Re: ***La Foret Certification Letter
El Paso County, Colorado***

This letter serves as the certification for La Foret, El Paso County, CO consistent with El Paso County Engineering Manual ("ECM") Section 5.10.B, which states, " *Engineering Record Drawings shall be accompanied by a certification letter from the Engineer of Record*". As the Engineer of record, I, Kevin Kofford, certify the site and adjacent properties (as affected by work performed under the County permit) are stable with respect to settlement and subsidence, sloughing of cut and fill slopes, revegetation or other ground cover, and that the improvements (public improvements, common development improvements, site grading and paving) meet or exceed the minimum design requirements. For sites including detention and/or water quality facilities, the certification letter shall include a statement that the facilities provide the required storage volume and will meet the required release rates, as documented by an attached UDFCD design form submitted with the original application, the stage areas, elevations and outlet dimensions.

DUE TO OUTFALL
CONSTRAINTS,
OUTFALL PIPE WAS
REDIRECTED WEST

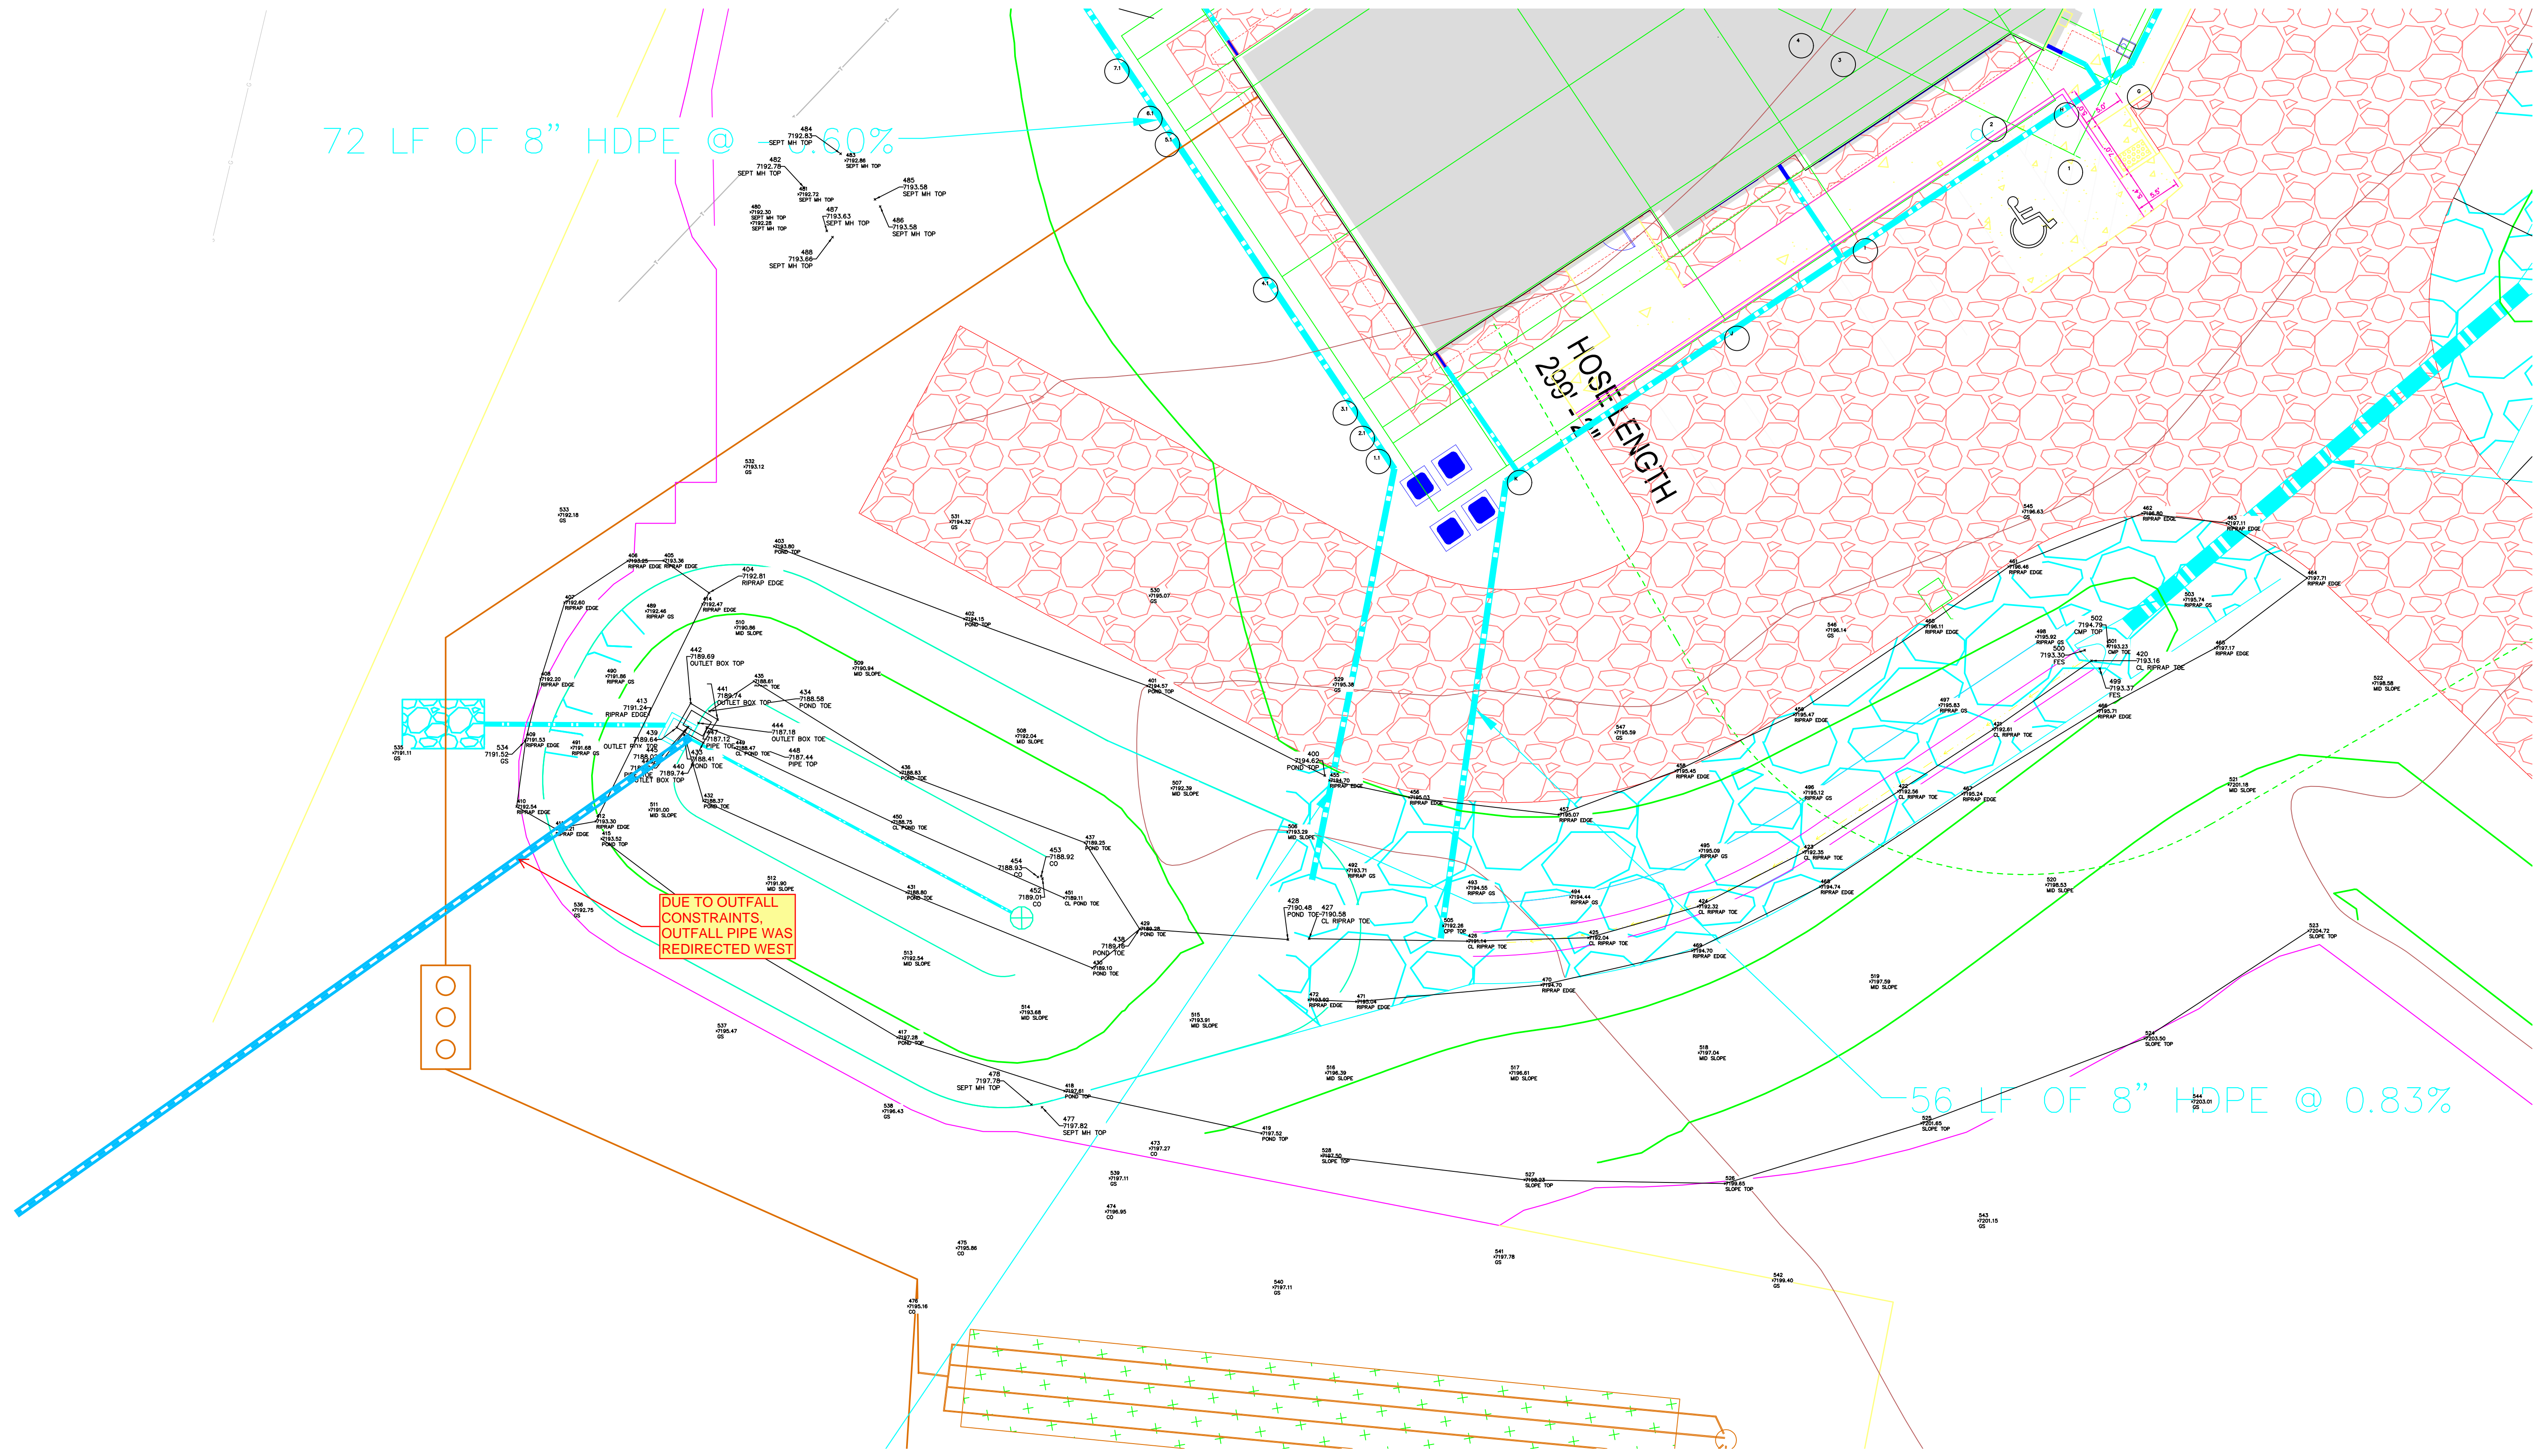
Unresolved from Submittal 1: Please show plansheet with changes and new shots overlaid - we need to get a better sense of the comparison between what was originally planned for and what changed.
This is just a screenshot from CAD it does not have engineer stamps or engineer record drawings label. Please overlay changes to original plans.
